Date: 13 December 2022

**Application by Drax Power Limited for an Order Granting Development Consent for  
the Drax Bioenergy with Carbon Capture and Storage Project**

**Procedural Decision following request to make changes to the application**

DRAWING TITLE
 PROPOSED UPDATE TO LAND PLANS (TO BECOME LAND AND CROWN LAND PLANS) IN RELATION TO PROPOSED CHANGES (SHEET 1 OF 4)

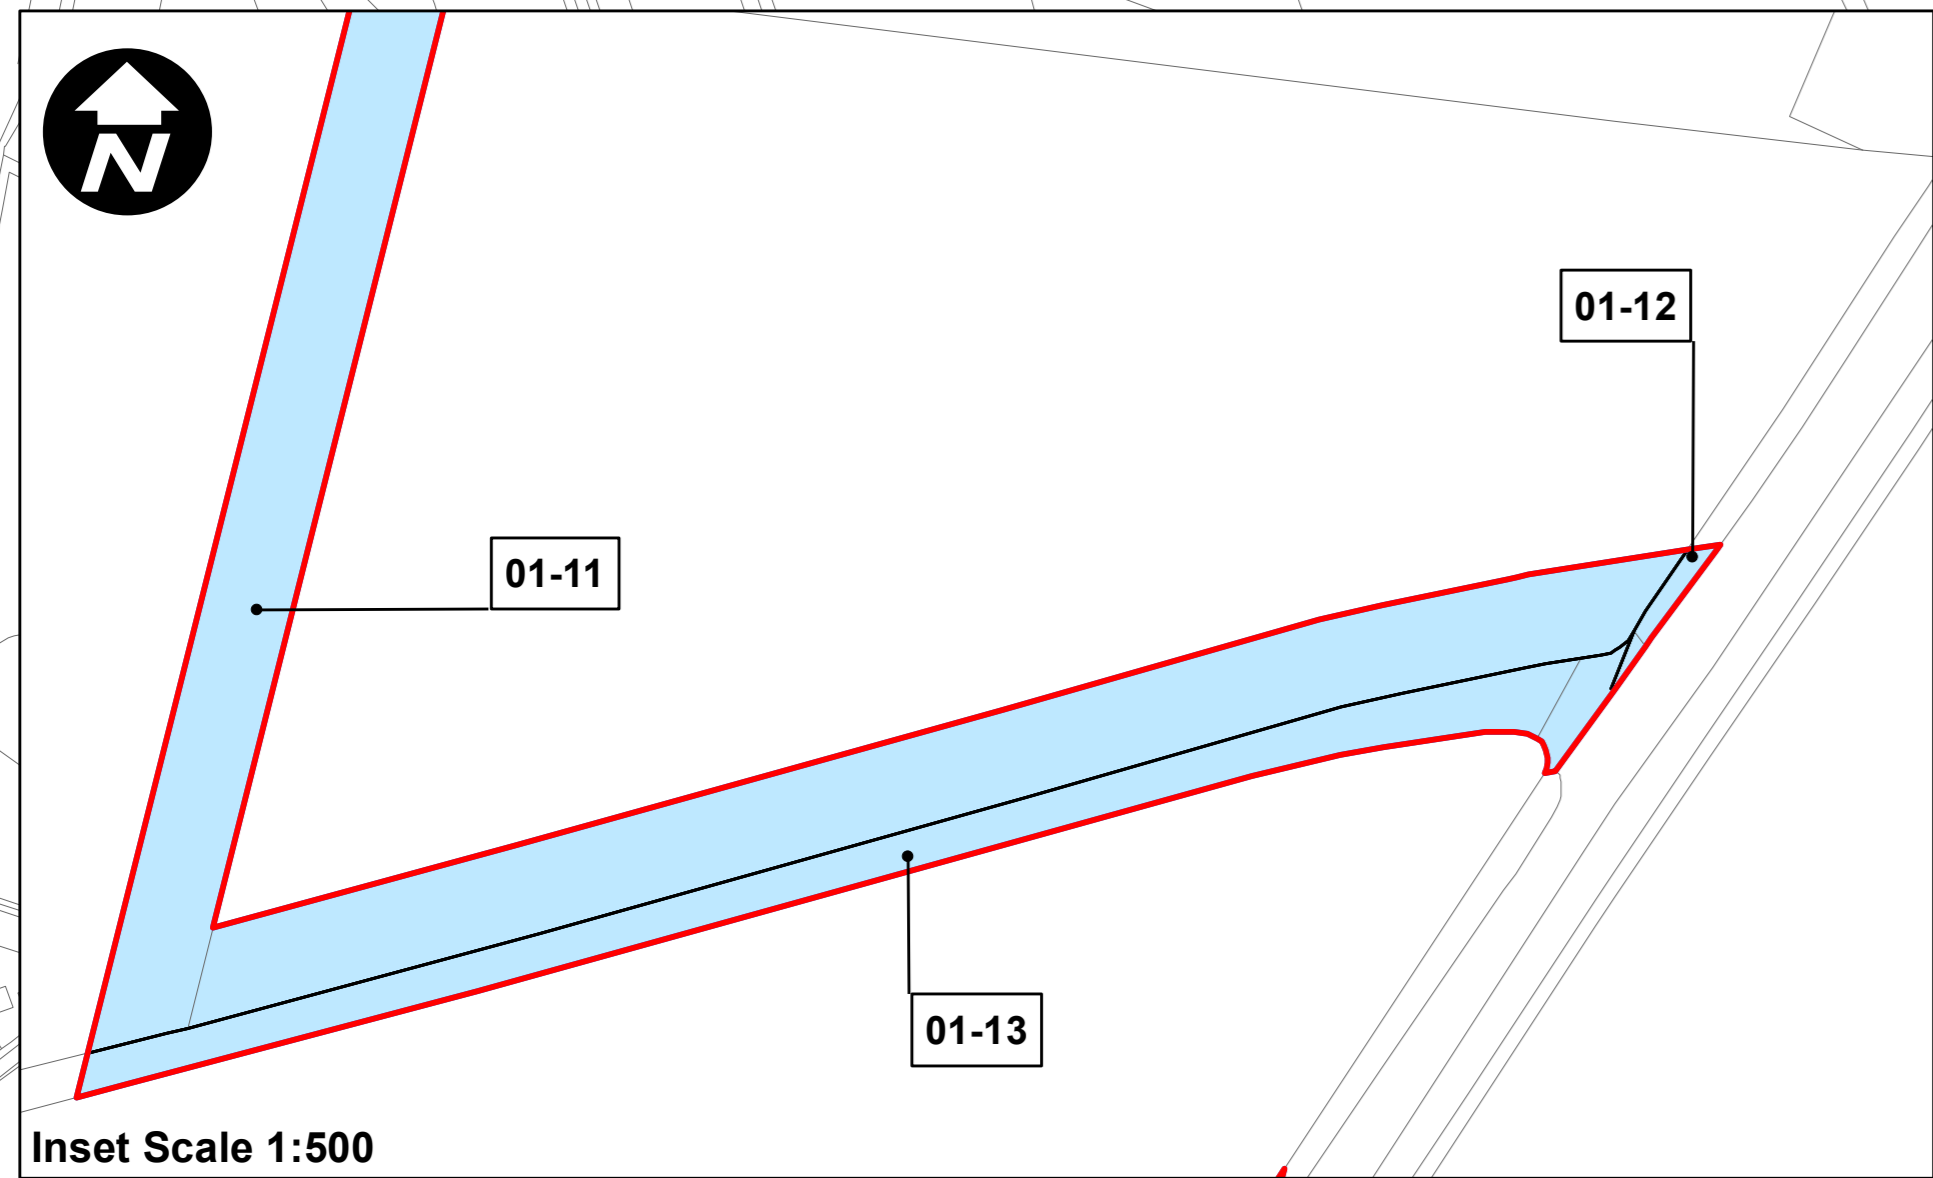
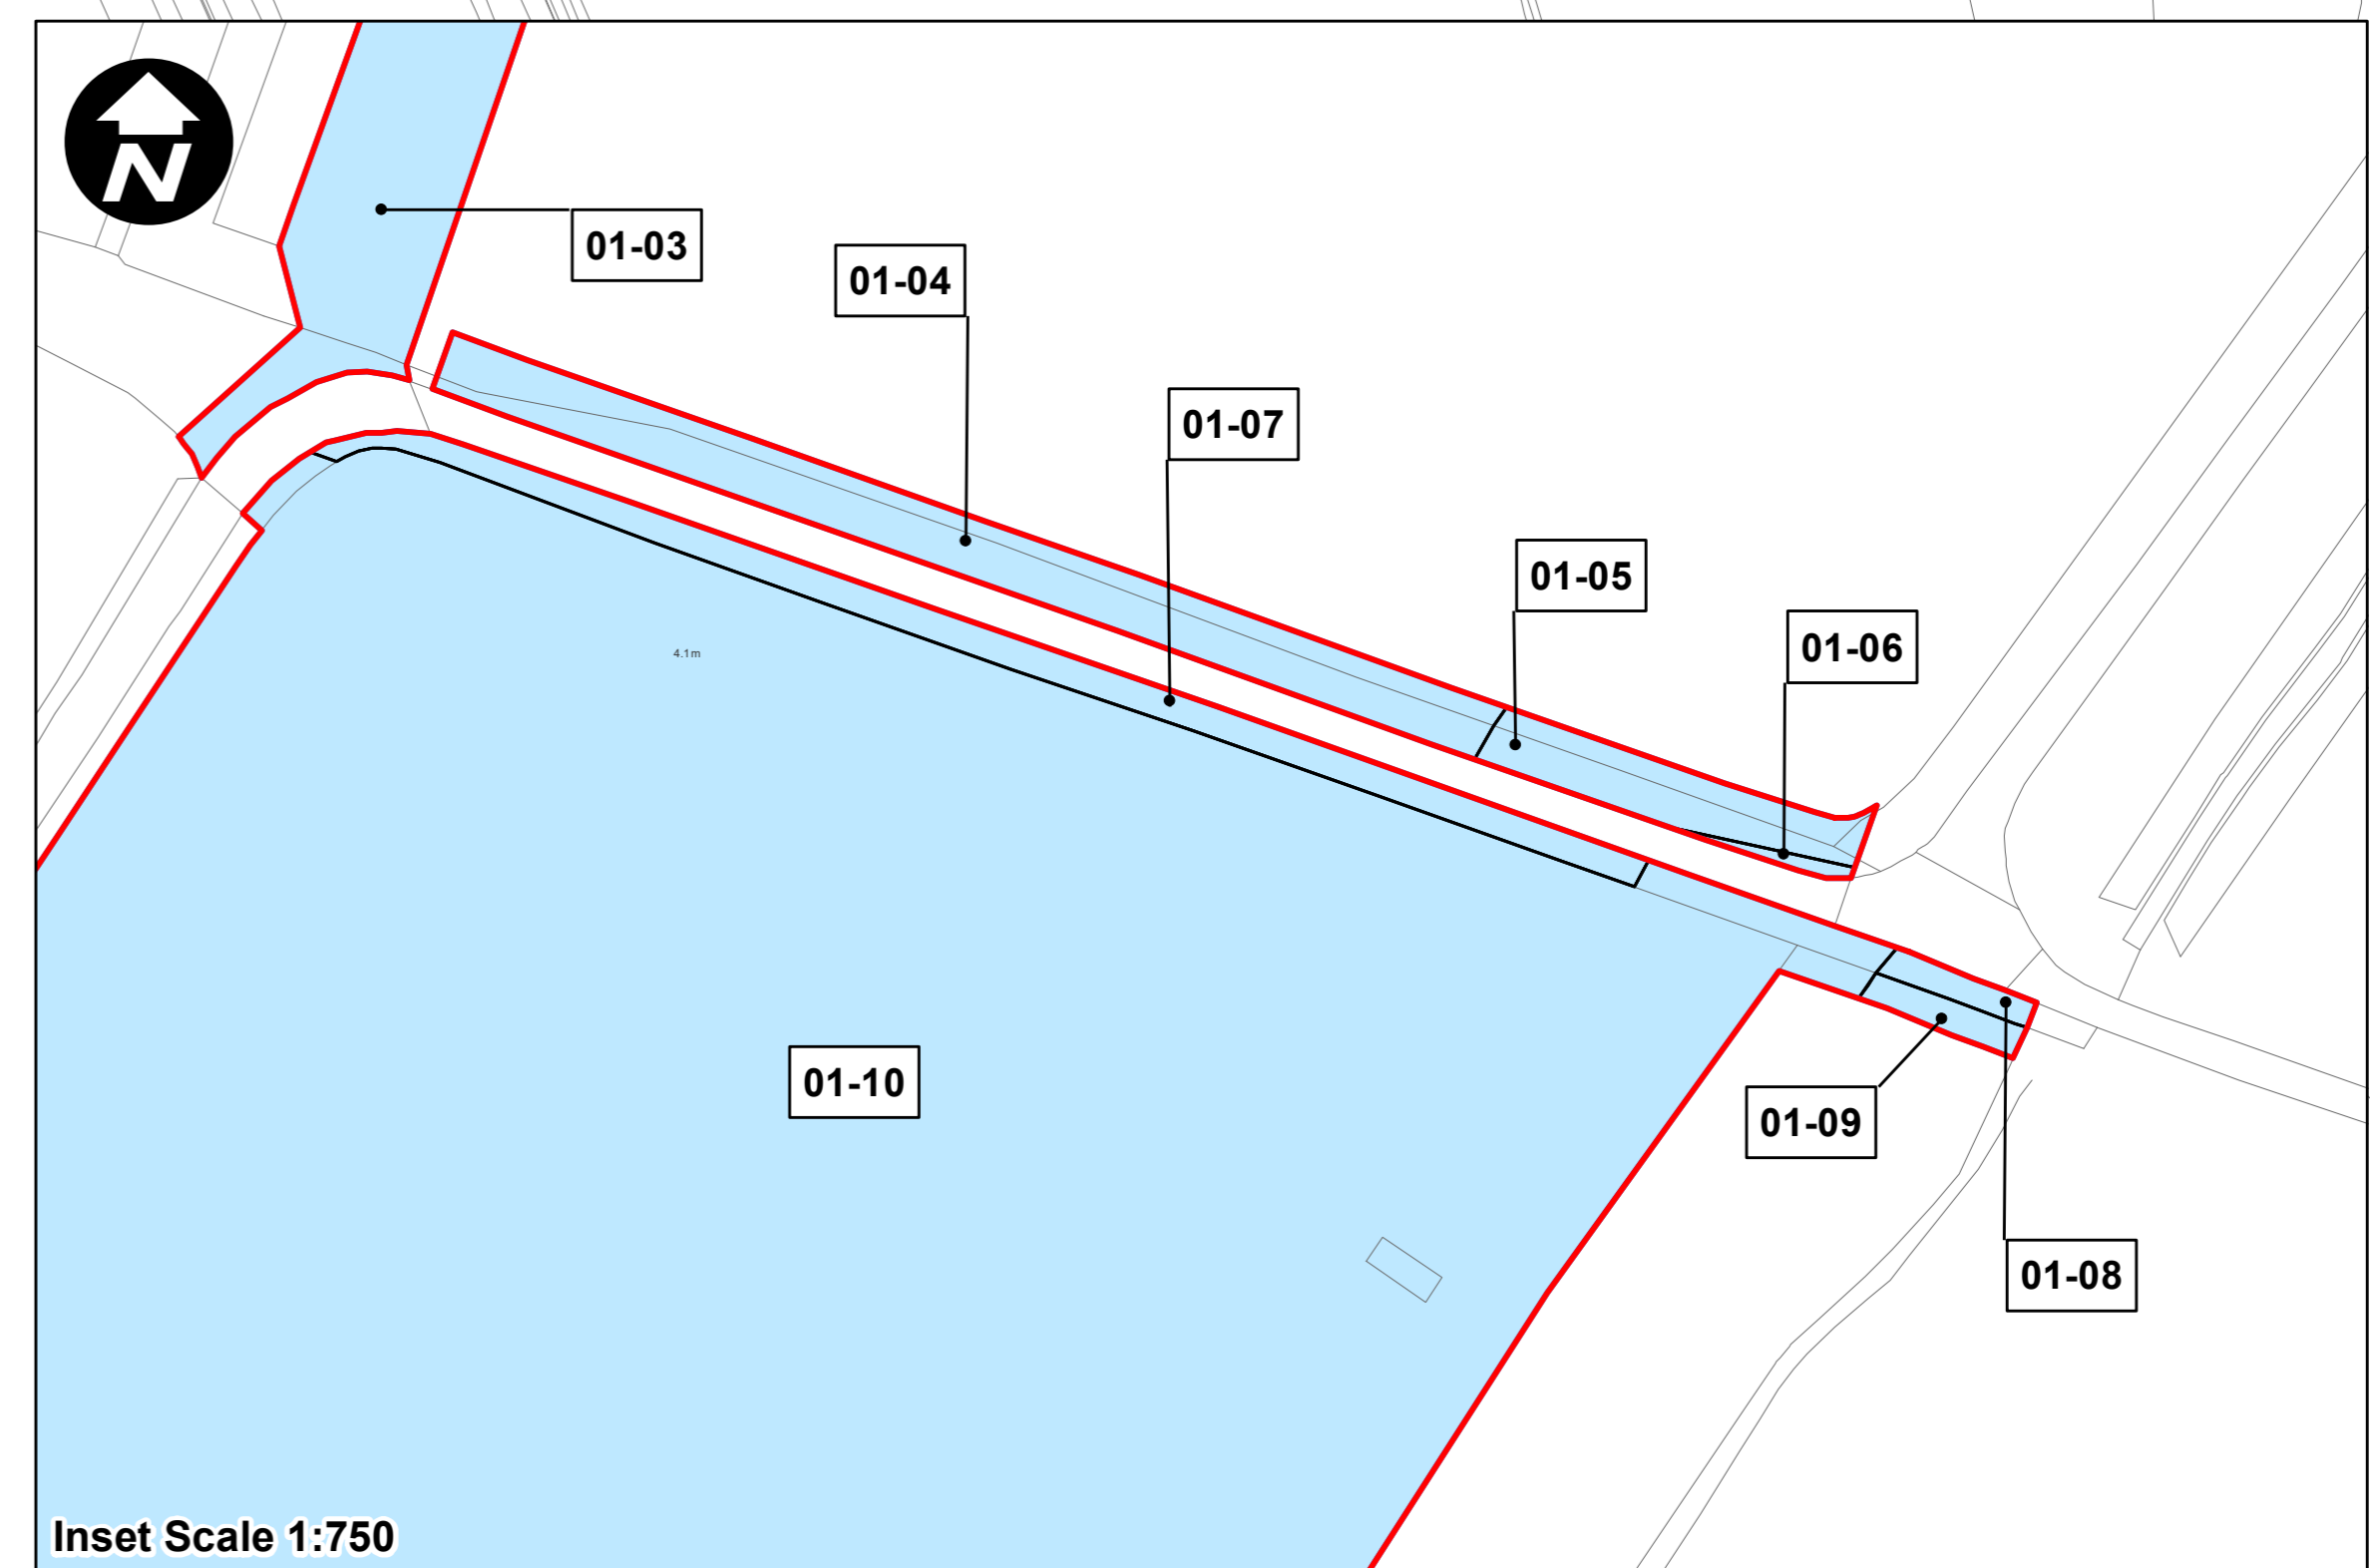
In reviewing the submissions for the change request, the ExA has made some observations on the Land Plans and Work Plans and would ask the Applicant to review and consider the below prior to the submission of its consolidated updates on 3 January 2022:

- Plots 01-82 and 01-92 on the Land Plans each appear to comprise two distinct sub-plots. Should each of these apparent sub-plots be individually numbered as a separate plot?
- Please provide an insert of 01-55 on the Land Plans for clarity.
- Should plots 01-47, 01-78, 01-80, 01-114 and 01-115 on the Land Plans be shaded green?
- Please ensure that a Key Plan in accordance with Regulation 5(4) of the Infrastructure Planning (Applications: Prescribed Forms and Procedure) Regulations 2009 is submitted with the updated Land Plans, as this is omitted from the Land Plans submitted with change request.
- Should centre lines be shown for Work No. 8 on the Works Plans given it relates to overhead lines?
